Application for a Non-Material Amendment Following a Grant of Planning Permission

Demolition of existing garage and erection of single storey rear extension, rear dormer extension and porch to side elevation.

2024/62/90883/W

Substitute original interlocking concrete roof tiles for smooth interlocking roof tiles - Grey colour

DWG NO:
274-PL208C

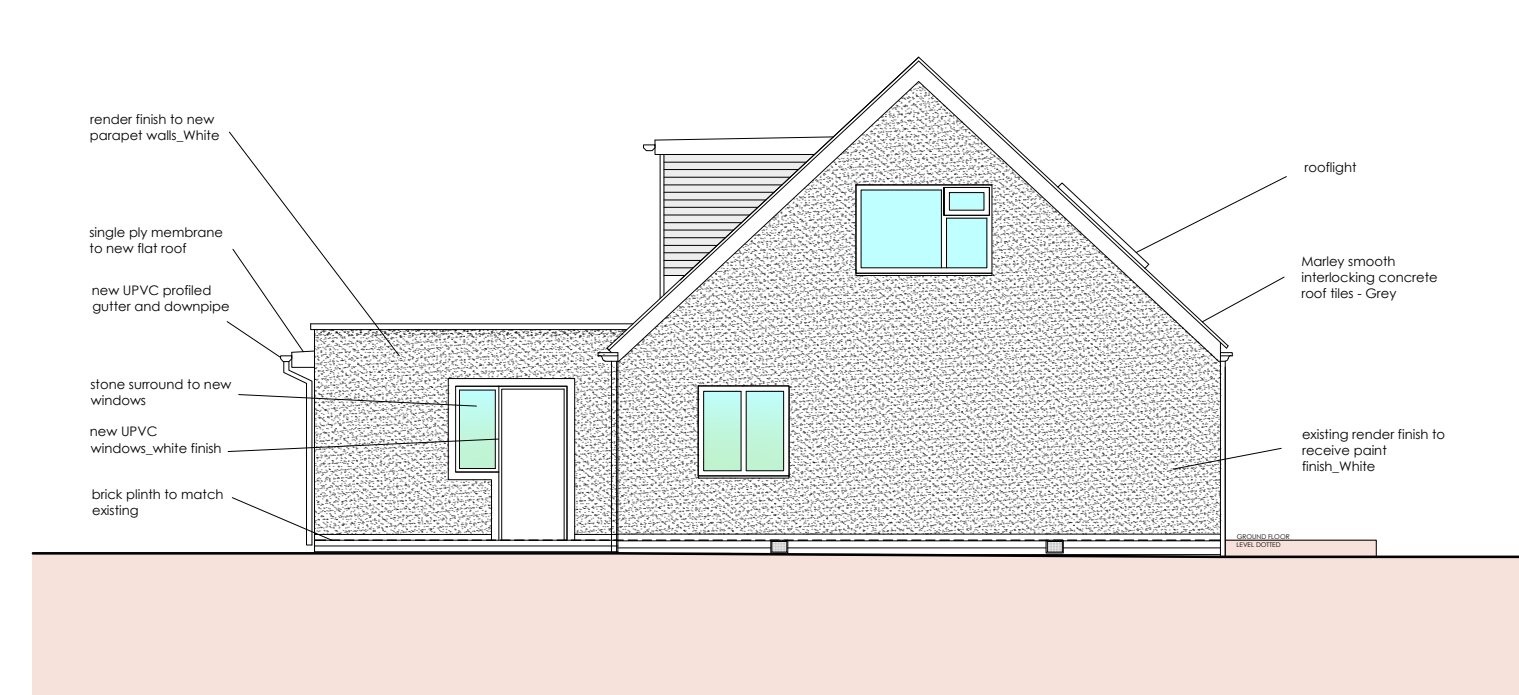
Following commencement of construction work to the roof, the existing roof tiles are in very poor condition and require replacement. My client is of the opinion that the smooth interlocking tiles are more aesthetically pleasing than the original and would compliment better the character of the renovation.
